**DEVIATION REVIEW
 AND DECISION FORM**

Address of Subject Property (Street Number/Name): 11910, 11930, 11950 Tourmaline Dr
 Tax Schedule ID(s) #4230319054
 Legal Description of Property: LOT 4 THE SHOPS FIL NO 1 AT MERIDIAN RANCH
 Subdivision or Project Name: The Shops at Meridian Ranch

Section of ECM from Which Deviation is Sought: 2.2.5.D Roadway Access C

DRAWING NO.
1
 SITE DEVELOPMENT PLAN

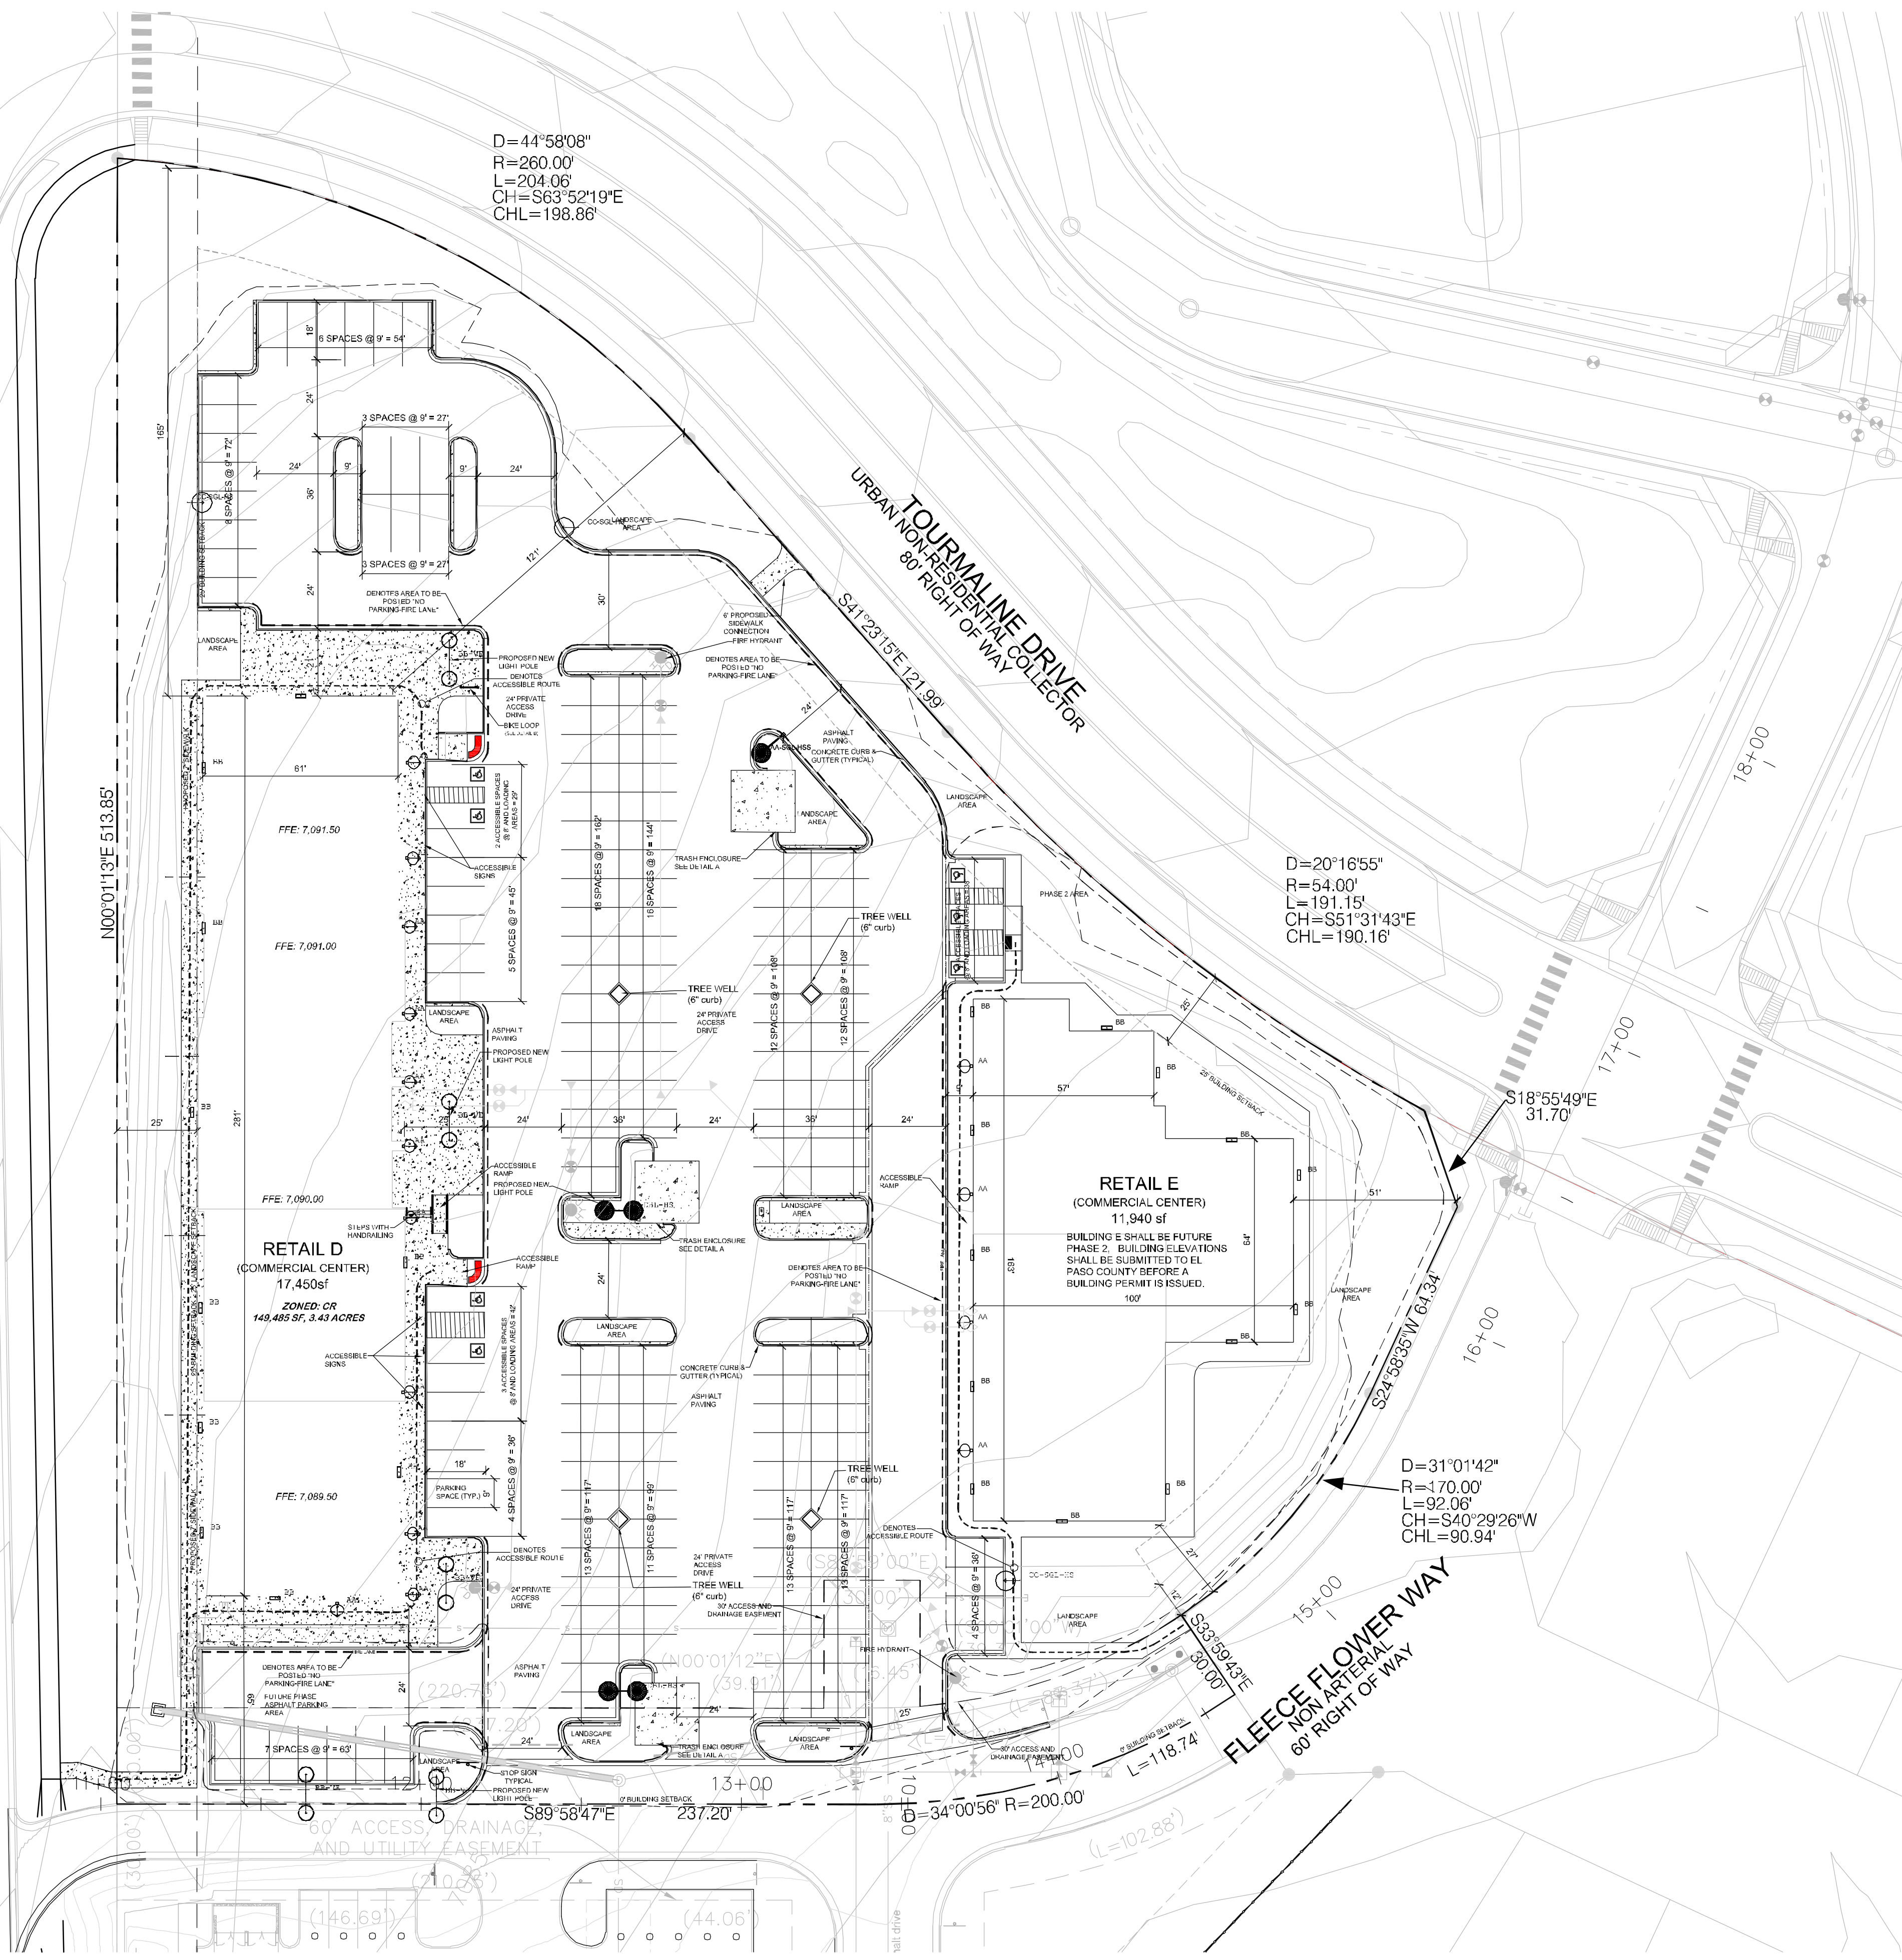
Revise. Site plan only shows RIRO for this access.

Revise. Site plan only shows RIRO for this access.
